Item No. **Report of the Head of Planning, Transportation and Regeneration**

Address 128D & 130D MANOR WAY RUISLIP

Development: Raising of roof to add 2 x studio flats, ground floor infill extension, single storey front extension and conversion of 2 x 1-bedroom flats into 2 x studio flats

LBH Ref Nos: **73728/APP/2021/3884**

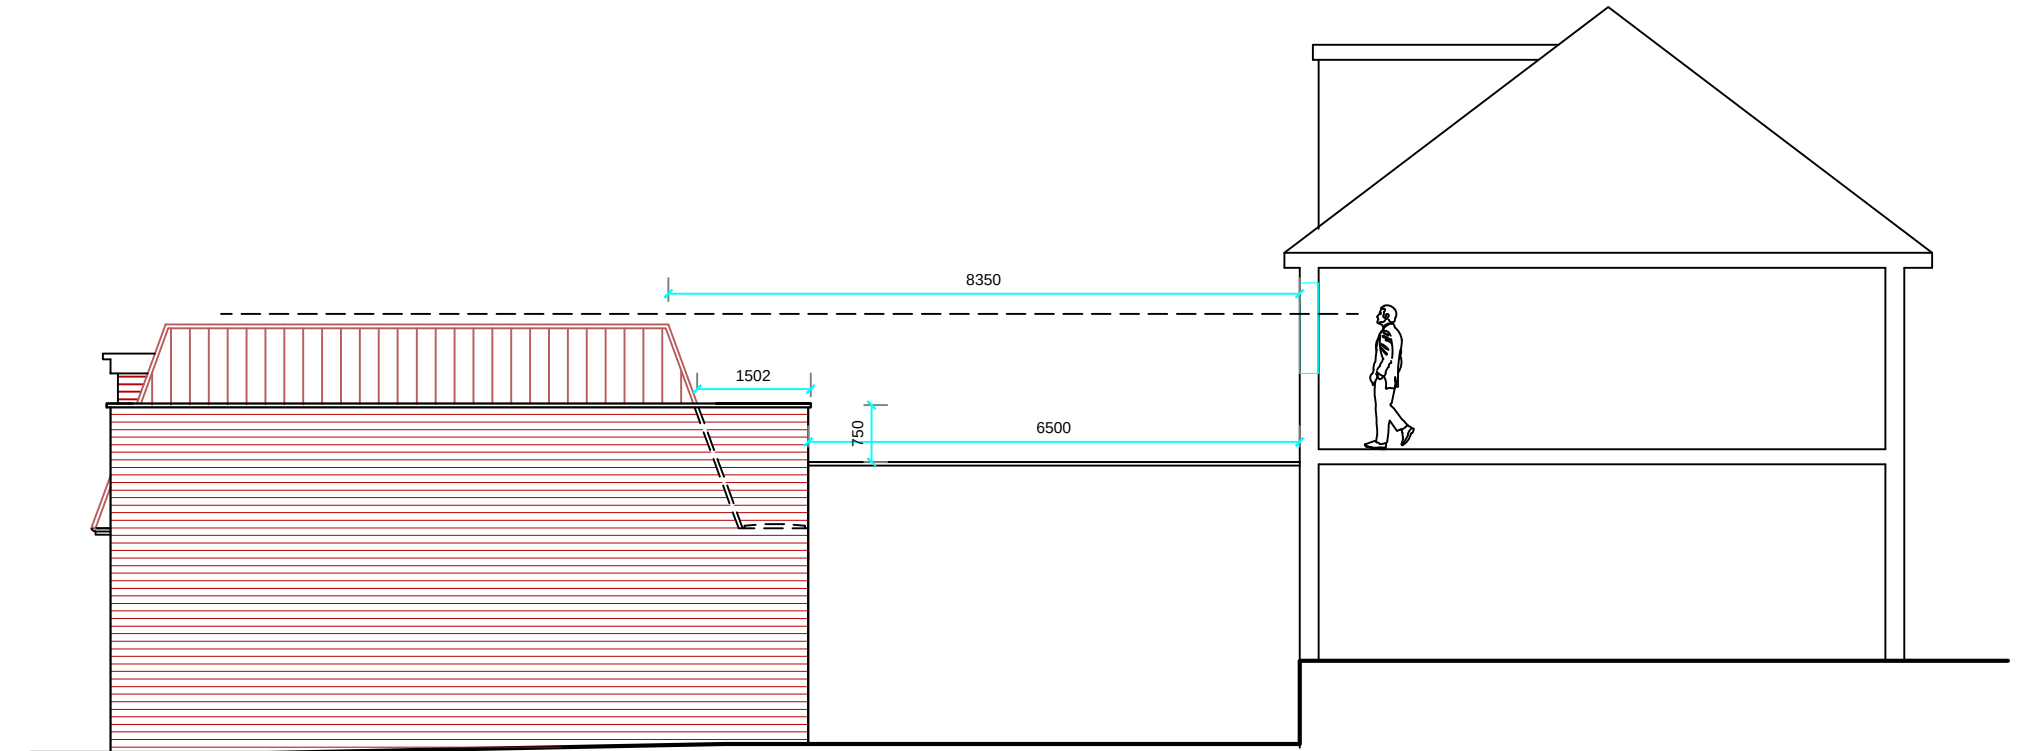
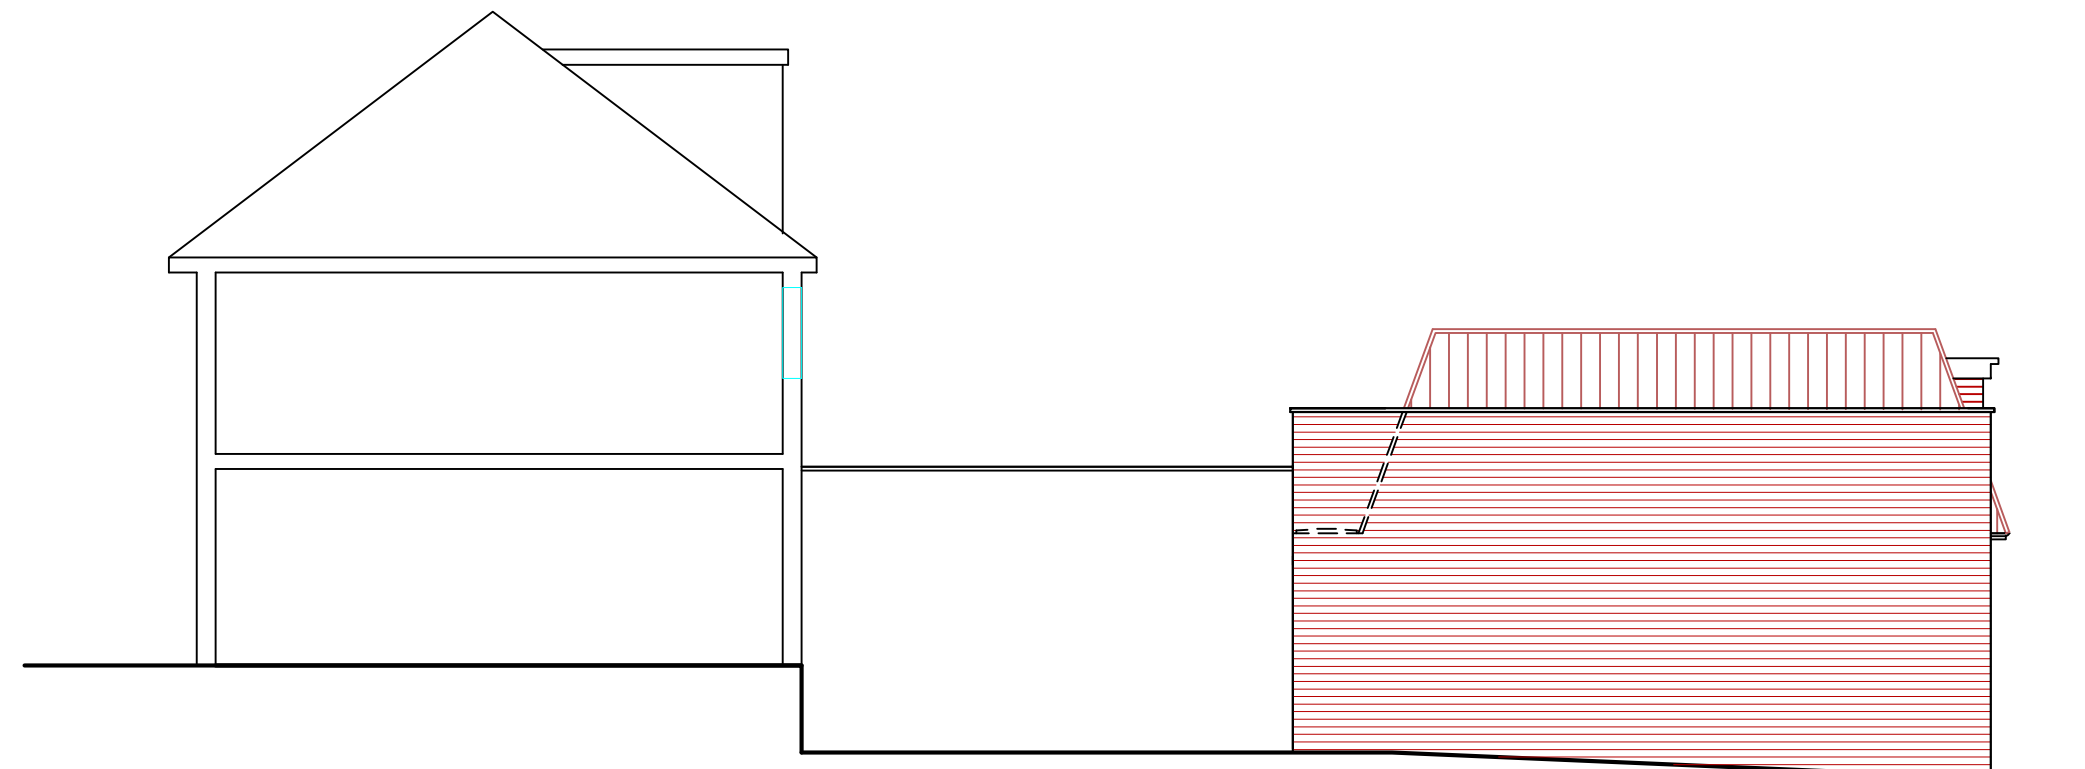
The proposed development, by virtue of the position of the front habitable windows and Juliet balcony of Flats 2 and 4 and their close proximity to the blank facade side wall at number 42 Windmill Hill, would result in poor outlook, overbearing impact and an oppressive living environment for the future occupants of these flats. The proposal would therefore result in substandard forms of residential accommodation to the detriment of the amenity of future occupants of the proposed development, contrary to Policy DMHB

The proposed development, by virtue of the position of the front habitable windows serving Flats 1 and 2 in relation to the existing service road and proposed cycle/refuse stores together with the proposed demolition of the existing boundary wall, would result in poor outlook, a loss of privacy and unacceptable noise and disturbance for the future occupants of these flats. The proposal would therefore result in substandard forms of residential accommodation to the detriment of the amenity of future occupants of the proposed development, contrary to Policies DMHB 15 and DMHB 16 of the Hillingdon Local Plan: Part Two - Development Management Policies (2020), Policy D6 of the London Plan (2021) and the National Planning Policy Framework (2021).

Notwithstanding the introduction of the proposed oriel bay windows, the primary views for the ground floor Flat 2, would be of the unrelieved and extensive side wall of No. 42 Windmill Hill. The proposed oriel bay window design of Flat 2 would not mitigate its close

proximity to No.42. This constrained and poor relationship would result in the flank wall of No. 42 being a dominant and overbearing feature, which would materially harm the quality of the outlook for the occupiers of the ground floor Flat 2. For the same reasons, the future occupiers of the upper floor Flat 4 would be afforded with an unacceptably poor level of outlook. This is despite of the proposed angled Juliet balcony and articulation to the upper rear of No. 42 (as identified by the Inspector of the above Appeal Decision).

The proposed removal of the boundary wall means that there would be no defensible space between the oriel bay windows of the ground floor flats and the adjoining service road, positioned only 3.8 metres away. Consequently, users of the private service road would be able to directly look into the ground floor Flats 1 and 2, which would result in a loss of privacy. Furthermore, the oriel bay windows serving Flats 1 and 2 would face directly towards the bin and cycle store, which further compromises the level of outlook afforded to future occupiers. The ground floor flats would be more susceptible to noise and disturbance associated with the private service road due to the proposed increase in depth, the position of the oriel bay window and the removal of the boundary wall.
